Regulatory, Planning and Assessment.MBisson/GMansfield  
Reference: SD2020/0006  
Phone: 02 4974 2000

5 July 2021

**38 LOOKOUT ROAD, NEW LAMBTON HEIGHTS - JOHN HUNTER HEALTH AND INNOVATION PRECINCT (SSD-9351535)**

CAD FILE NO.
N169770-SK04-P1.DWG

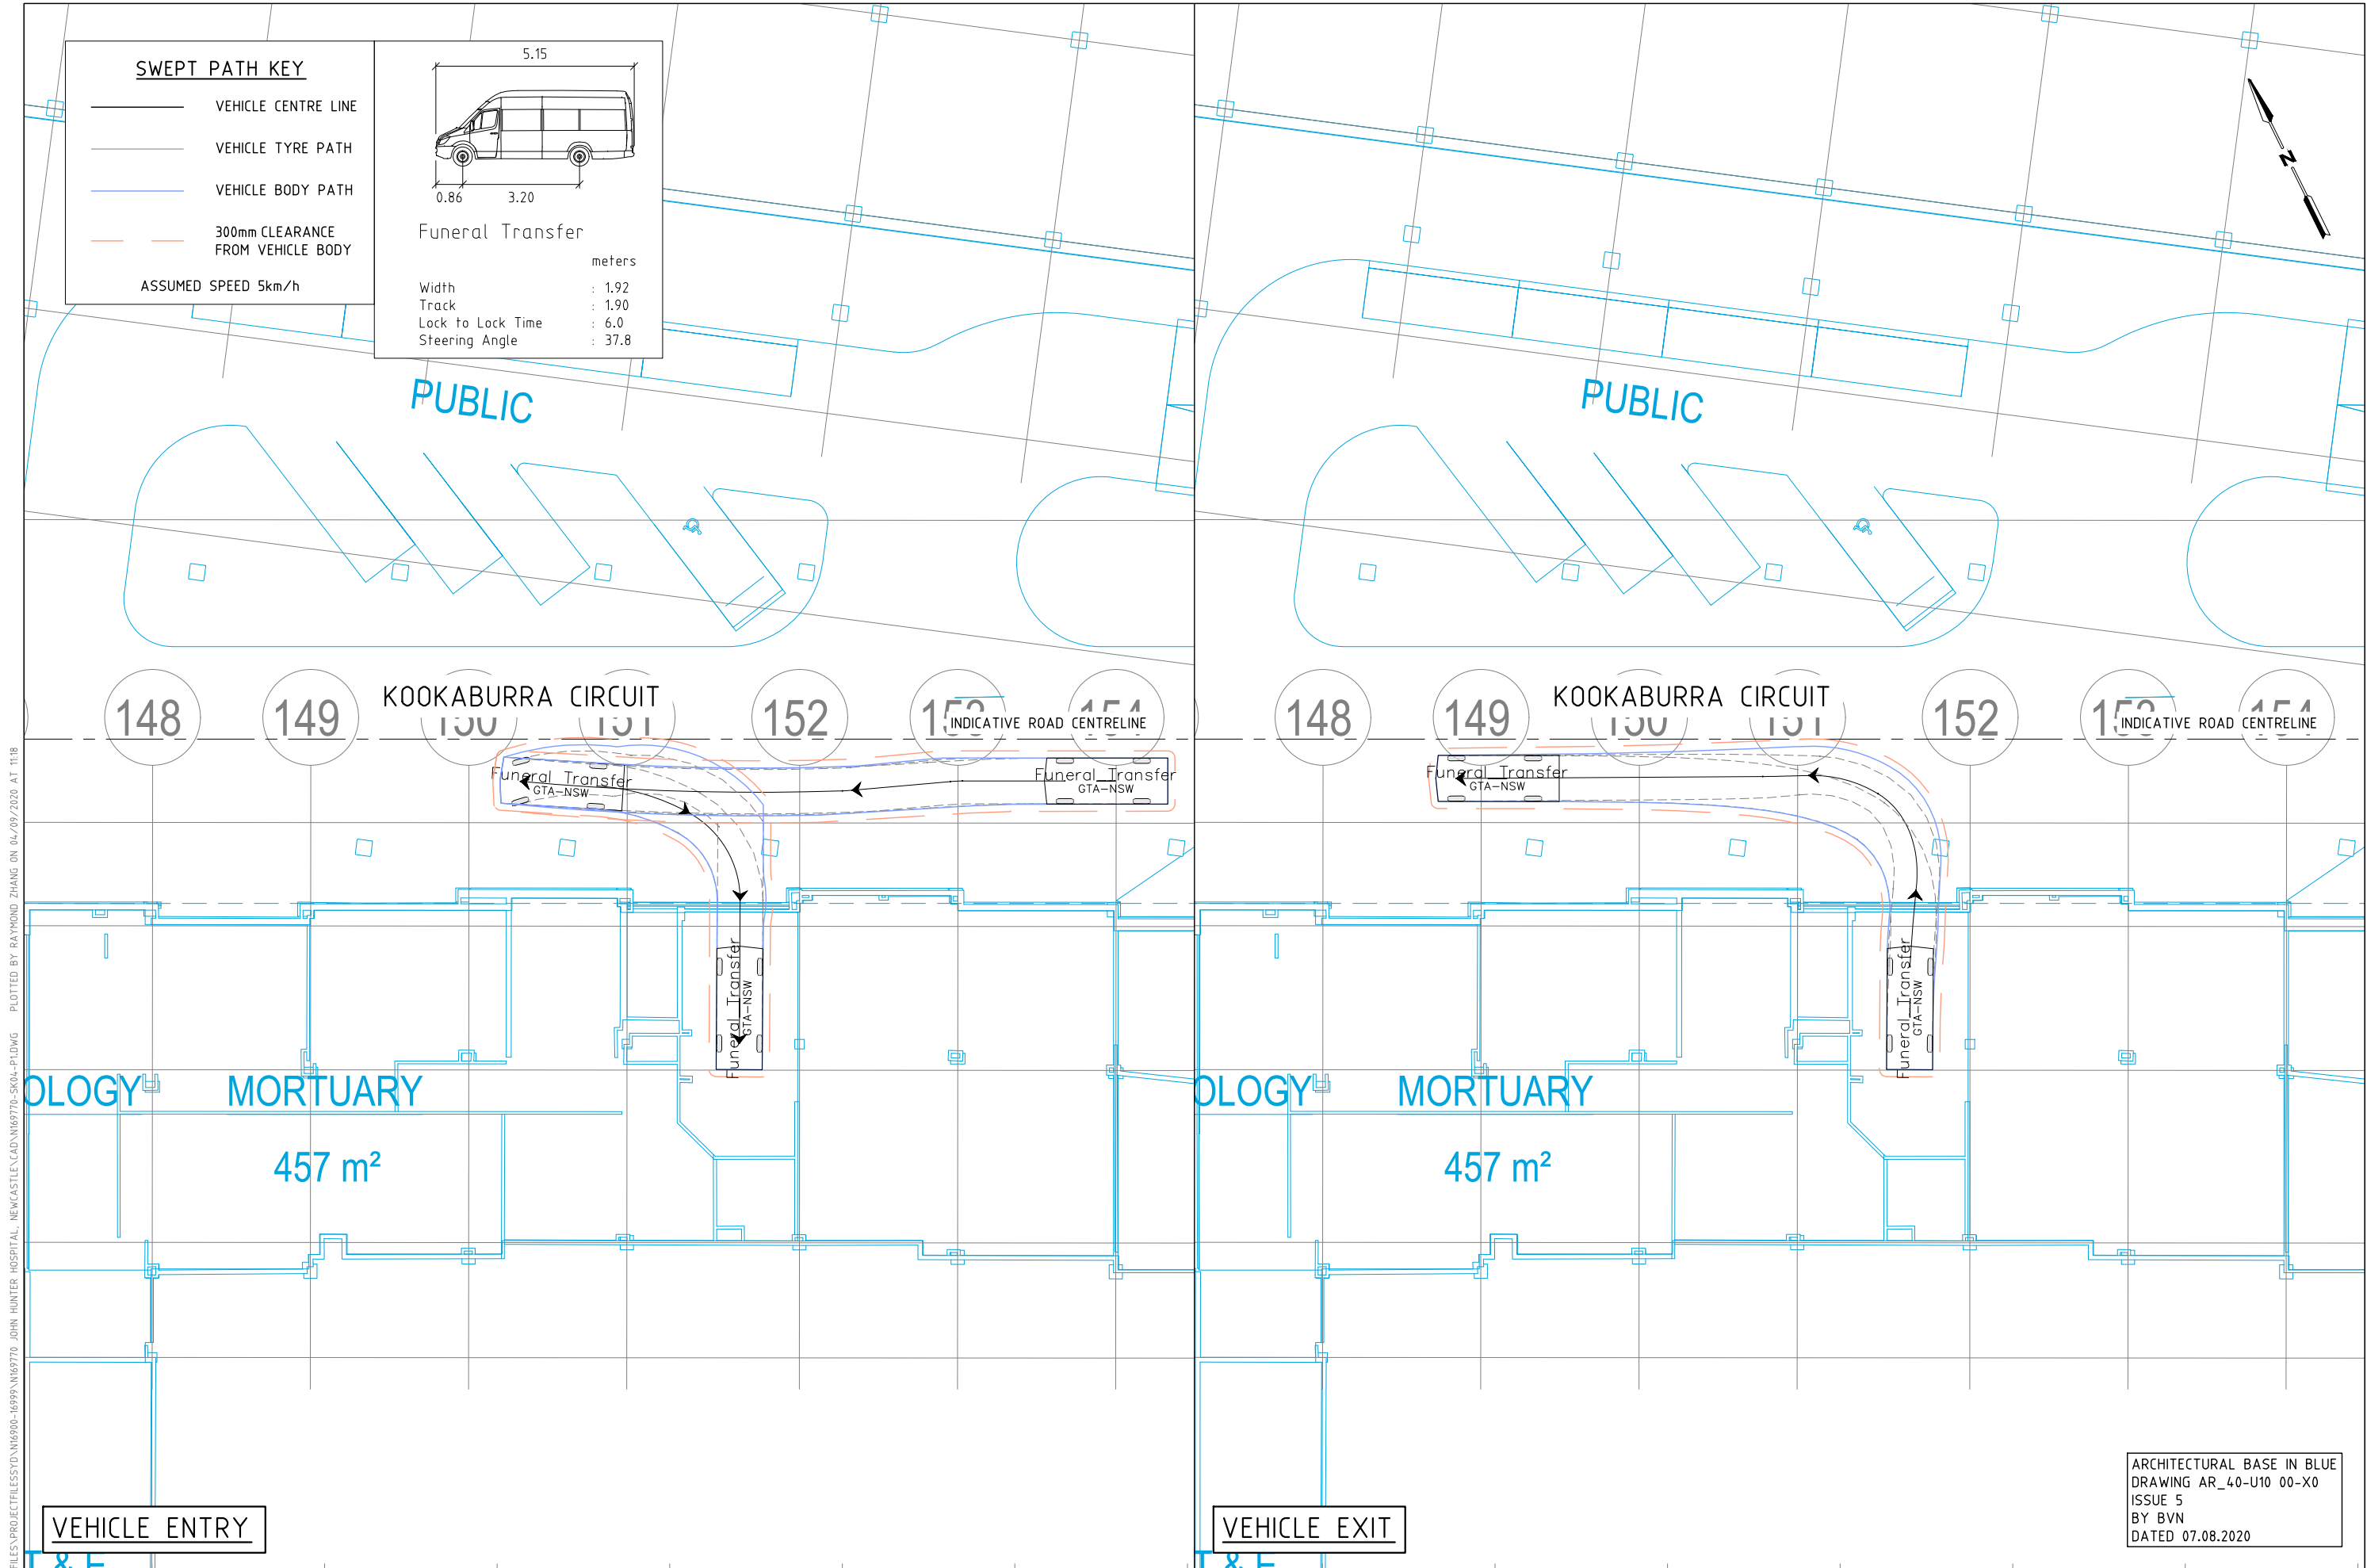
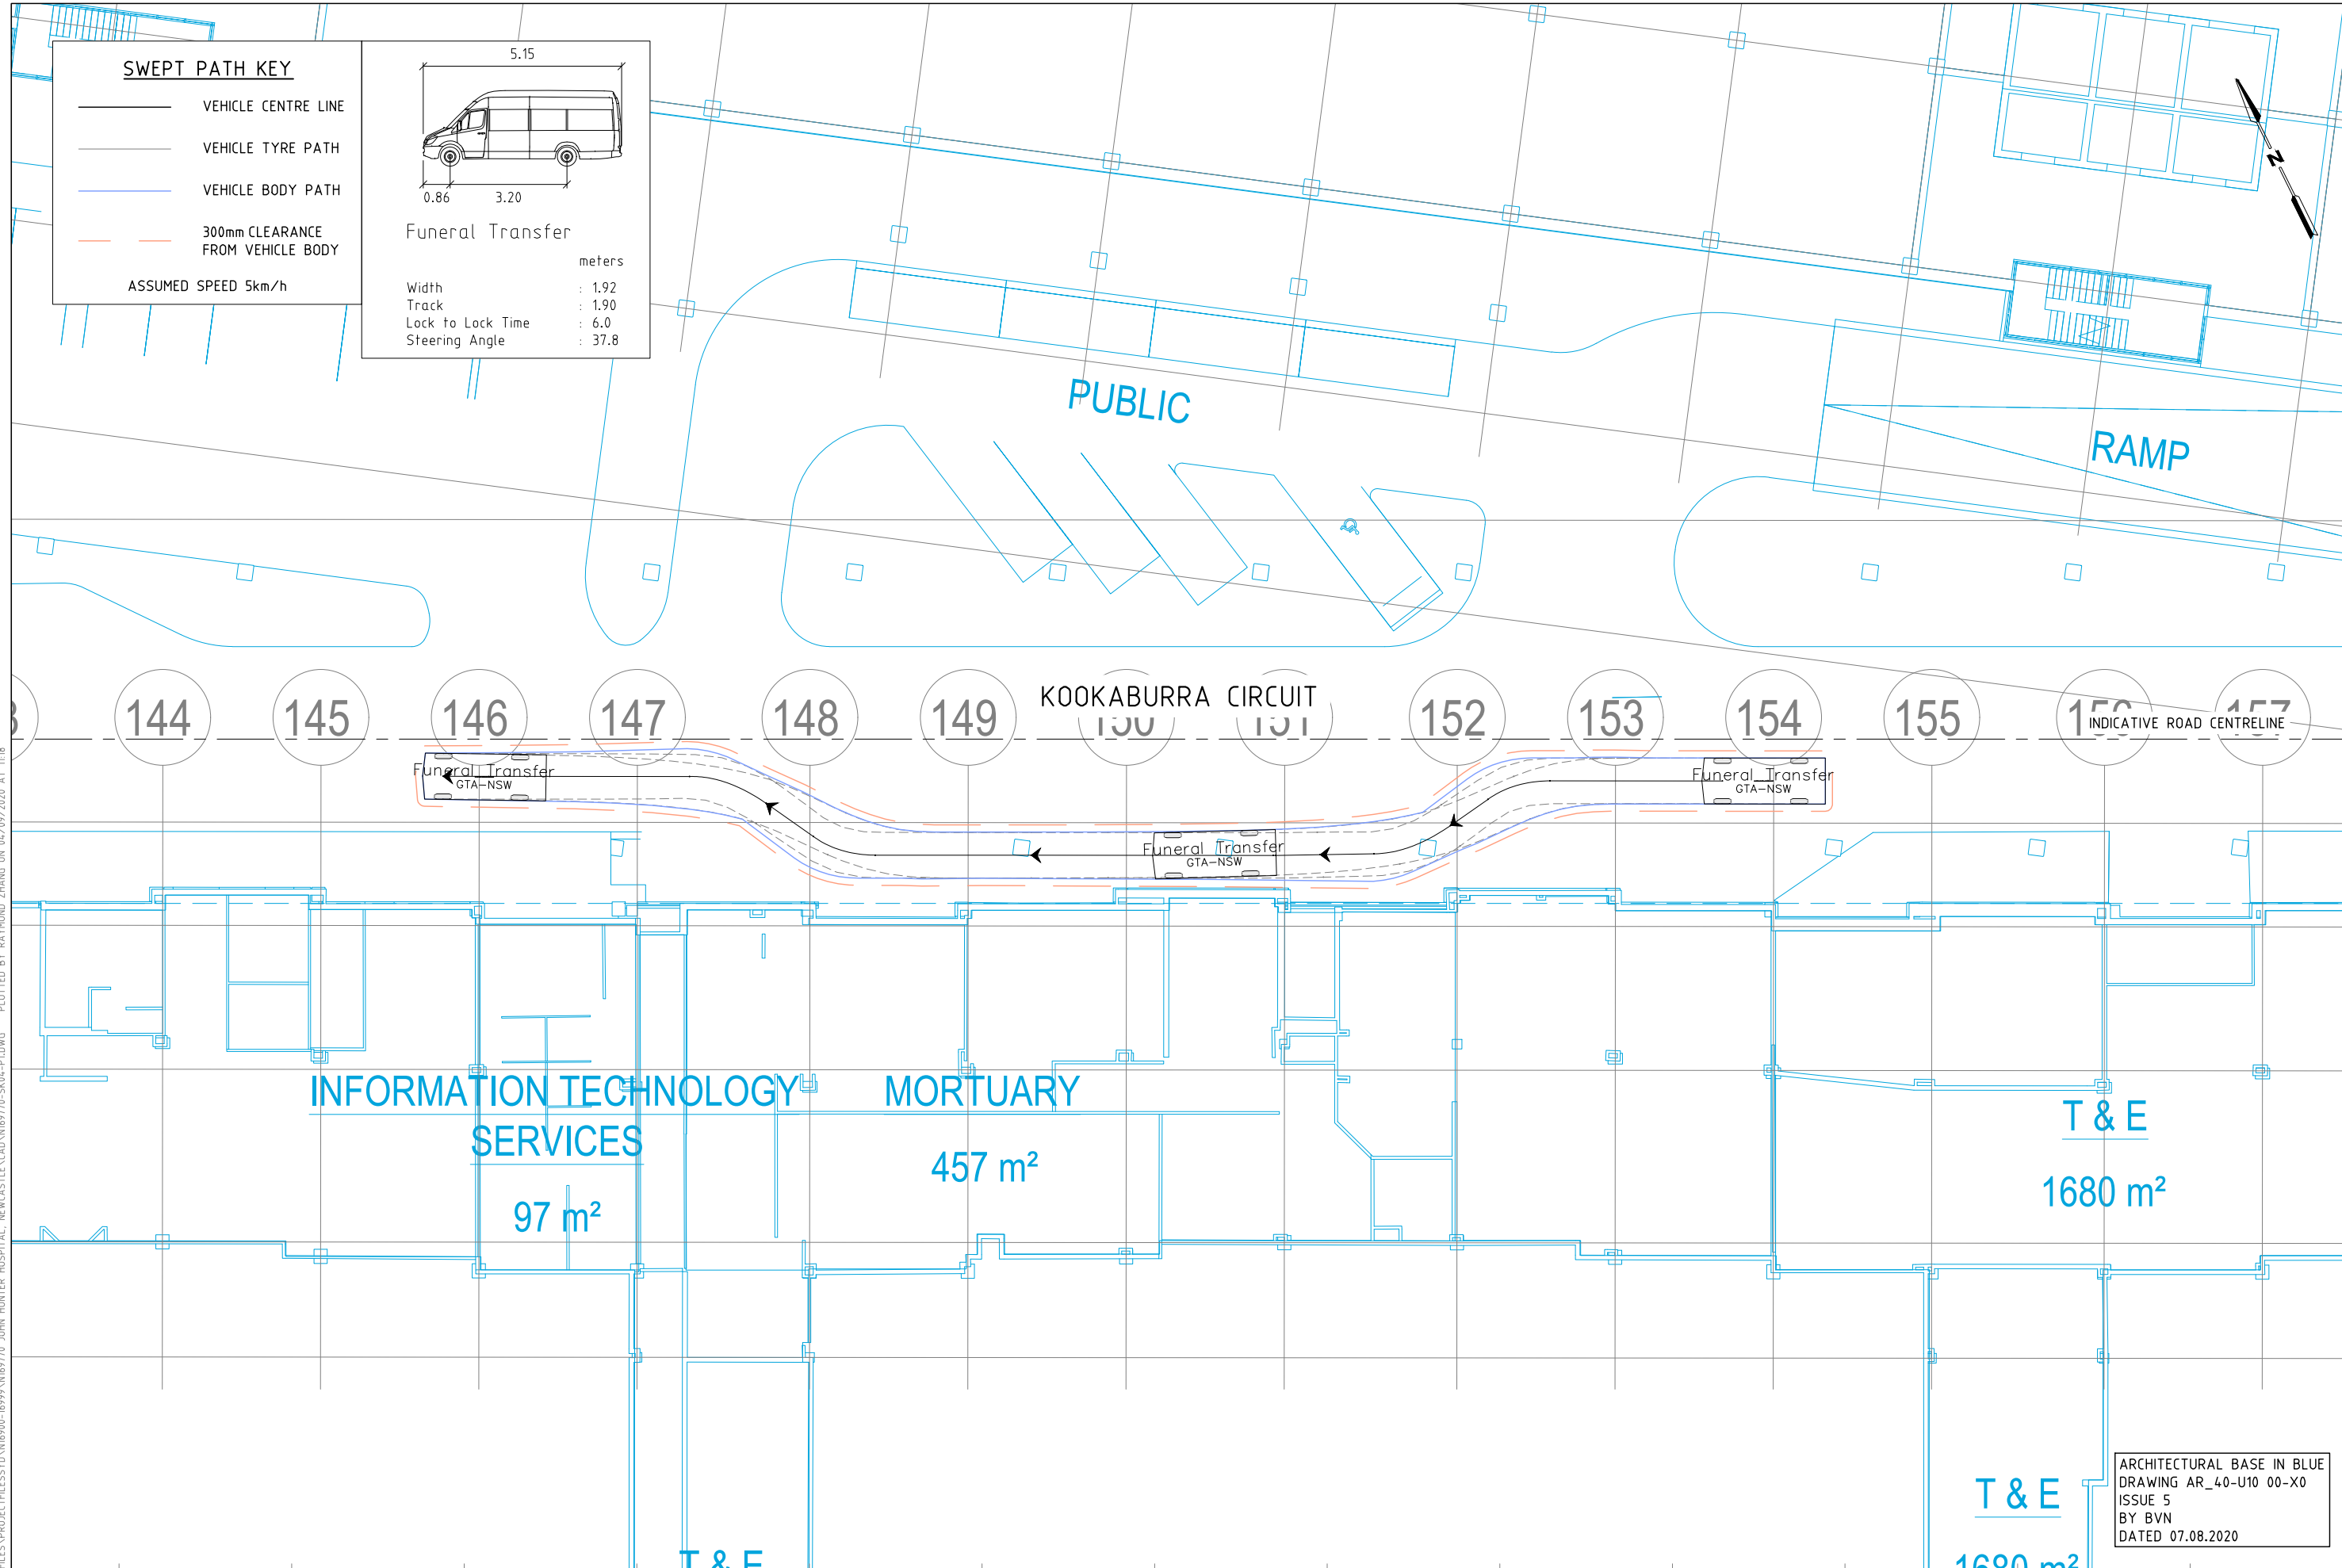
Furthermore, the vehicle Swept path plan prepared by GTA indicates that the northern section of Kookaburra Circuit between the proposed building and Jacaranda Drive allows for trucks to pass through the existing building underpass, thus appears to propose a two-way travel where it is currently one-way. This will likely result in additional works required within the road and the existing building, which has not been identified on plans. Height clearance at the underpass location would need to be confirmed.
